From: Sarah Burrow <Sarah.Burrow@arun.gov.uk>
Sent: 19 November 2019 15:22
To: Finlay Gardner <Finlay.Gardner@arun.gov.uk>
Cc: Planning.Responses <Planning.Responses@arun.gov.uk>
Subject: RE: Application BN/83/19/DOC

"Engineers Comments Regarding Surface Water Drainage Design"

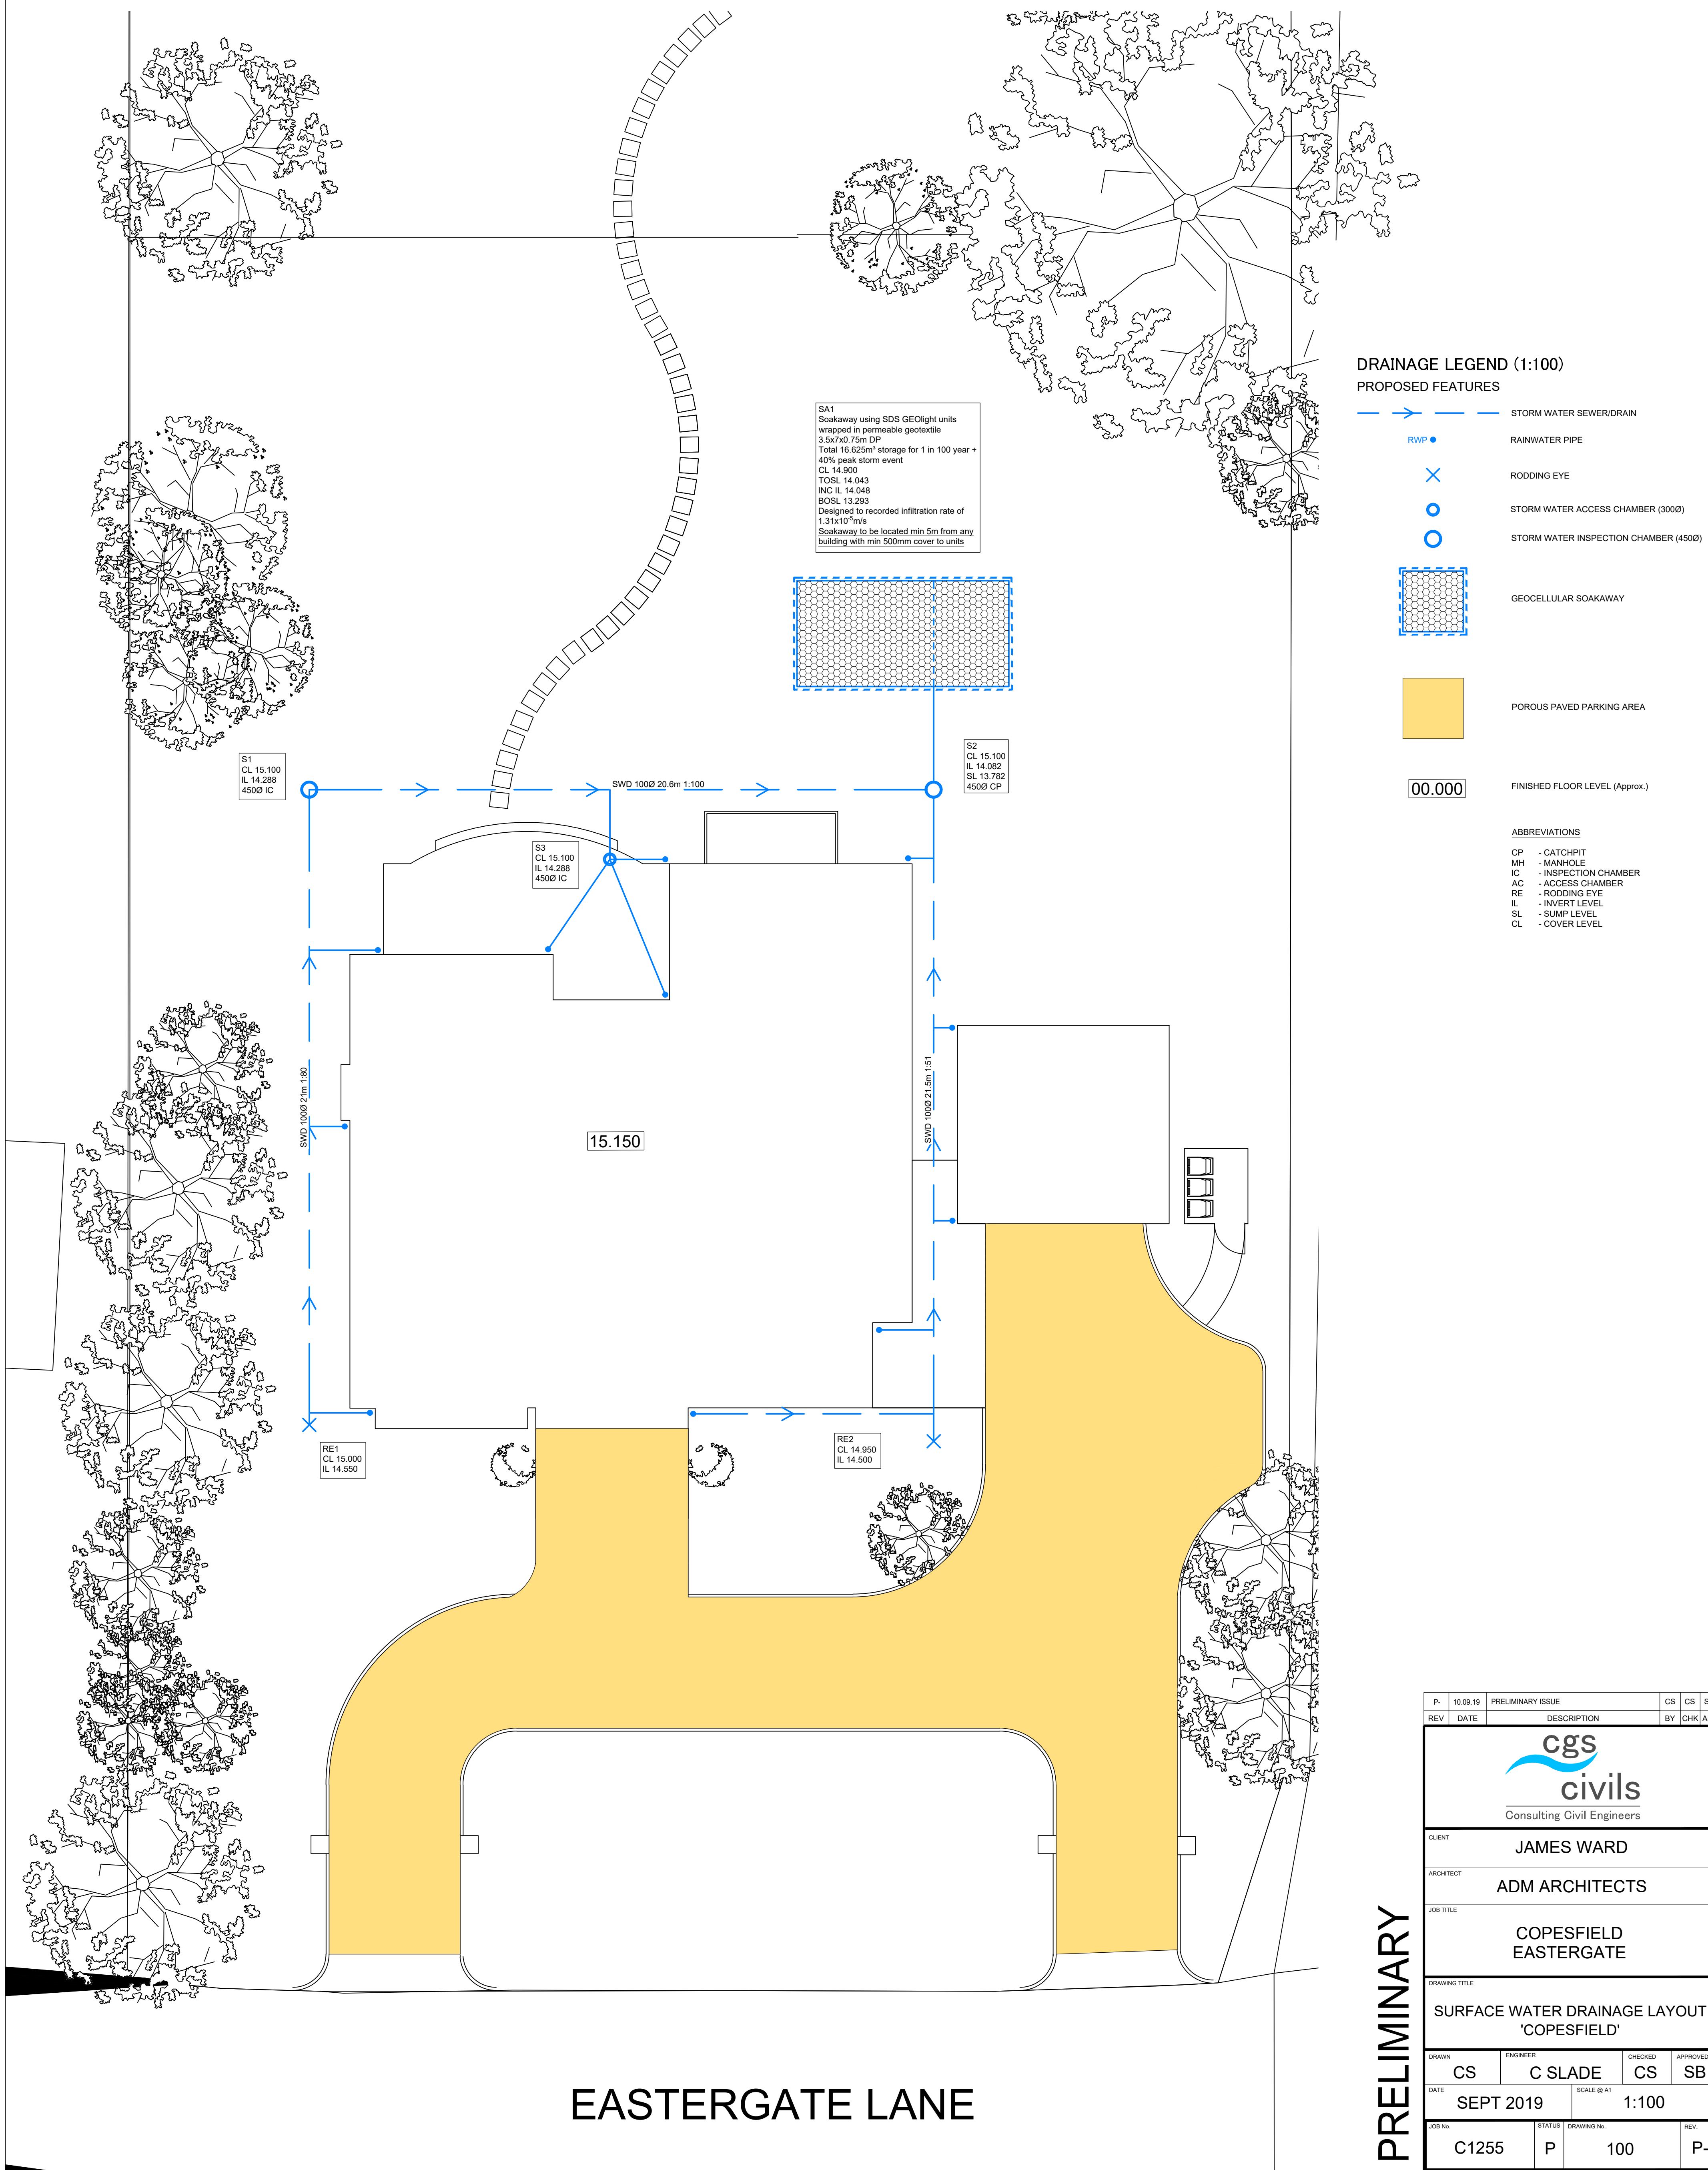
1. The proposed soakaways are at a greater depth than the infiltration testing depth. The applicant has two options; redesign the soakaways to a shallower depth with a greater surface area, OR, recomplete infiltration testing in accordance with BRE365 to a greater depth at an agreed time in the winter. However, the calcs show a different story in terms of proposed base levels – please clarify.

9. The silt trap construction detail sump depth does not correspond to that shown on the drainage layouts.
10. The percolation test hole dimensions do not comply with the requirements of BRE365 i.e. should be 0.3m to 1m wide x 1m to 3m long. Would welcome your comments in this respect.

1. The design has been adjusted to suit the testing and was re-submitted. Calculations attached again indicating shallower soakaways.
2. Attached
3. The porous paved area will self-drain similar to any landscaped areas albeit with the addition of extra volume in the sub base. Calculations for this type of porous paving do not reflect this as flows are directed to a specific node on the network as opposed to the whole areas. The testing revealed similar strata throughout all depths so infiltration rates will be similar. If this is unacceptable then we will connect into a soakaway and increase the size to suit. Levels now taken and added the porous paving. Please confirm why Type 3 is preferred over a 5/20mm stone. We have retained the 5/20 stone otherwise we will lose any warranty with the manufacturer.

8. Ratio-R adjusted to 0.35
9. Sump depth adjusted on drainage layout
10. Agreed and going forward we will bear this in mind as this was not an issue on previous applications. The calculations stay the same so we would like to keep the tests as they are.
